8th May 2019

Planning Application: REF K/9/19/HH
Kingston Corner, Brookside Rd, Kingston Gorse, BN16 1SE

Please consider the comments here-in as support for my OBJECTION to the application above. I write as the owner and occupier of Sea Barn, the neighbouring property situated directly to the south of Kingston Corner.

GA - Proposed Elevations looking South & looking East 2

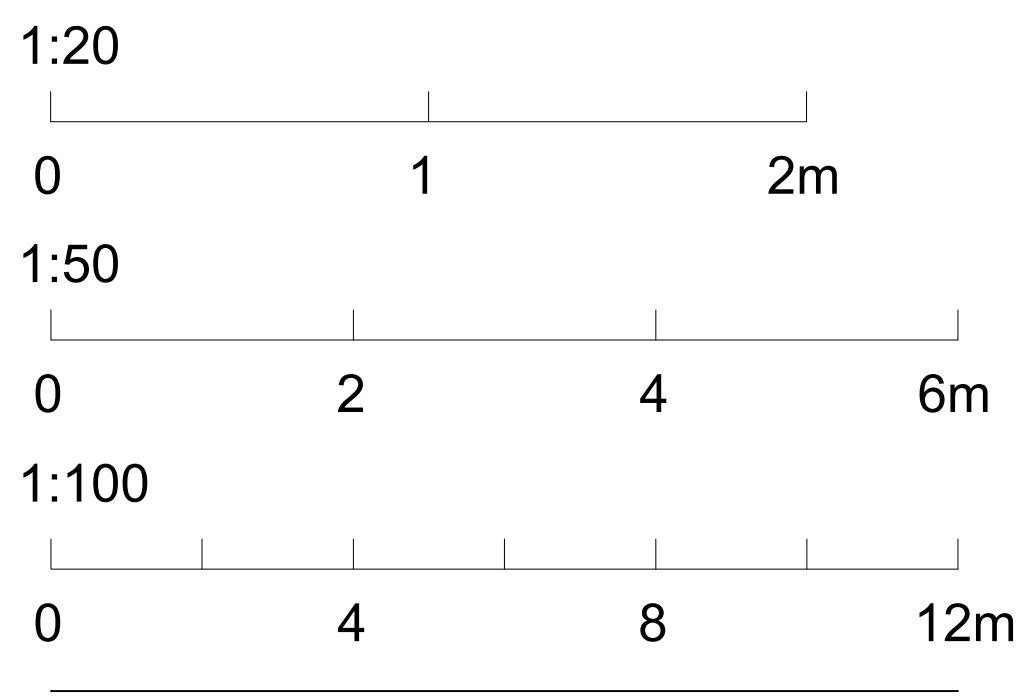
The design and access statement (p.10) states that the proposed two storey development will have a ridge height of 5m from the ground and that the building will be sunk 1m below ground level, however the elevations and sections show a building with a total height of 6.2m, and a ridge height above the ground of 5.5m. The hedges adjacent to the new development that sit on the border of the boundary between Sea Barn and Kingston Corner have been drawn at 8m, but the hedge that sits on this boundary varies in height between 5.4m and 3.1m at the point where the hedge is adjacent to the development. The section of the hedge that is 4.3m high runs at that height for 13m adjacent to where the proposal is situated. Contrary to the design and access statement that the development 'will be practically invisible' from Sea Barn, the variations in hedge height mean that the proposed development will be clearly visible from ground level at both ridge height and up to 1.3m below ridge height. From the two north facing windows on second storey of Sea Barn, the proposed development will be visible at ridge height and up to 1.2m below ridge height (again variations in the hedge height have been taken into account in these estimations). Notwithstanding the above reduction in privacy, any residual privacy is entirely dependent on the aforementioned privet hedge, a natural barrier - should this be subject to compromise in any way then this would further compromise Sea Barn's sense of privacy and it is noted that the proposed development's 26m depth (west to east), which will run adjacent to Sea Barn, is also longer than the total depth of Sea Barn, which has an equivalent west to east depth of 21m. This is all significant with respect to the visual impact and overpowering and intrusive nature of the proposal on Sea Barn, which is contrary to Arun District Council Local Plan policy D DM4 – Extensions and Alterations to Existing Buildings and Kingston Neighbourhood Plan policy KNP7 - Design and Development, section 1 (i), (iii) and (iv).

GA - Proposed Elevations looking East 1 & looking West

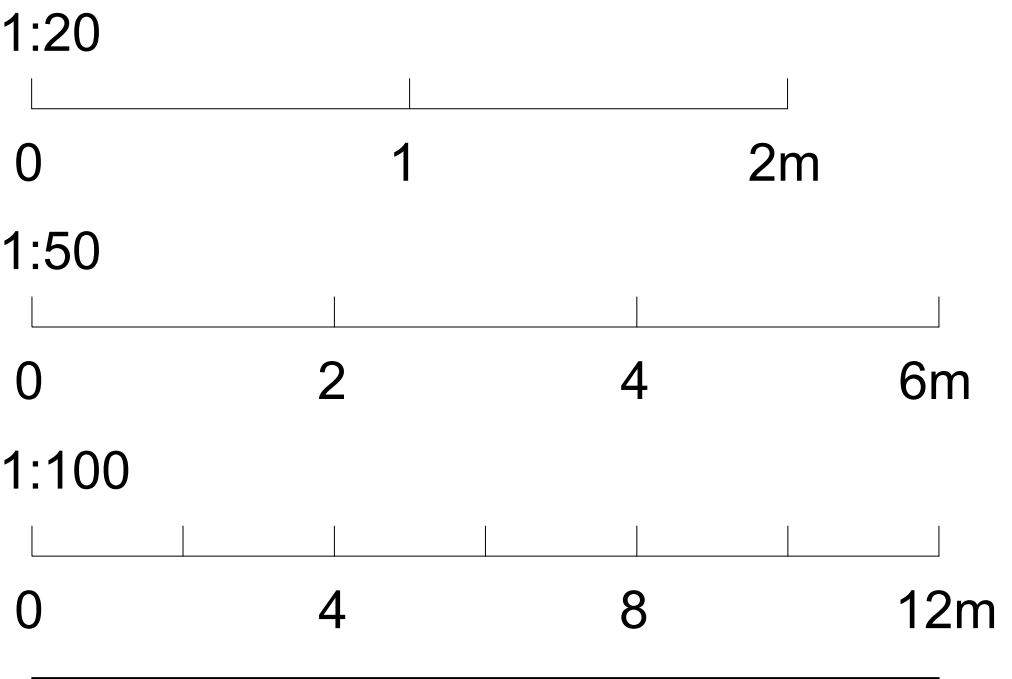
The design and access statement (p.10) for the proposed two-storey replacement will have a footprint of 129m², 3.8 times larger than the existing single-storey 34m² shed and although smaller than the 181m² footprint of the existing main house, it will have a depth running front to back (west to east) of 26m that exceeds that of the main house (23m). The proposal exceeds the existing building line of the built area of the site at the front (west) and brings it closer to the road in an area in which, generally, buildings are set well back

from the road. In addition the proposal also marginally exceeds the existing building line to the rear (east) of the existing house. The proposed development uses materials that are very different from the existing house. The development will have a footprint that is 71% of the existing main house and its massing is out of keeping with the scale and proportion of the original building. All of the above is contrary to Arun District Council Local Plan policy D DM4 – Extensions and Alterations to Existing Buildings and Kingston Neighbourhood Plan policy KNP7 - Design and Development, section 2(iii).
